Harnett County Government Complex  
307 Cornelius Harnett Boulevard  
Lillington, NC 27546

September 13, 2005

**Re: Status of Improvement Permit Application #05-5-12968  
Lot 16 Colonial Hills**

**PRELIMINARY  
PLOT PLAN**

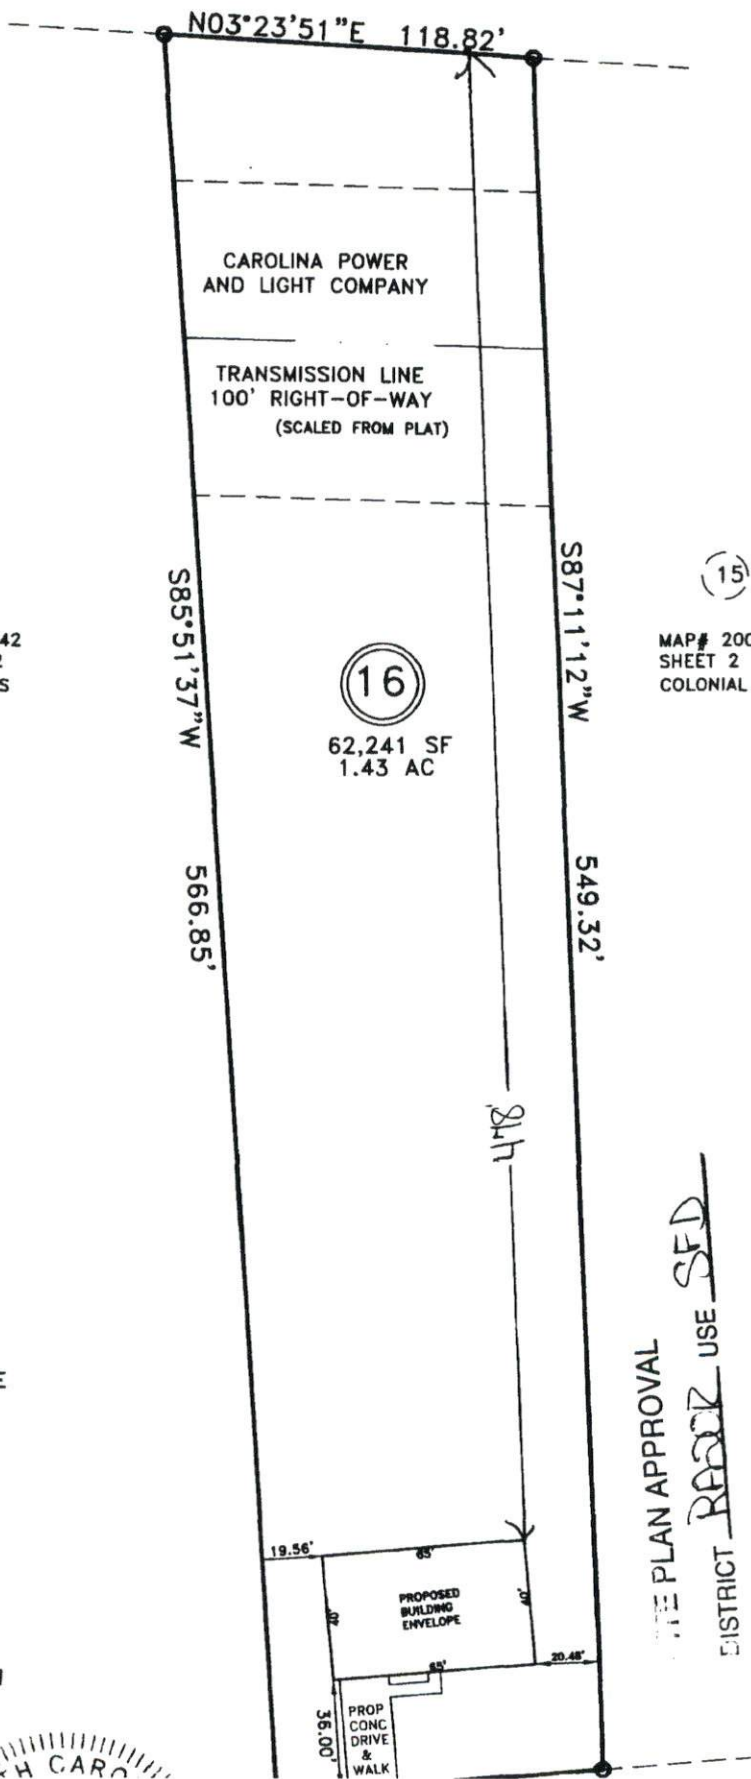
- 1. Property lines/corners not marked or labeled
- 2. House corners not marked or labeled
- 3. Directions not clear to property
- 4. Property needs brush or vegetation removed
- 5. Backhoe pits required
- 6. Other **Due to large amounts of soil disturbance on your lot, you will need to have the private consultant provide septic system layout and design.**
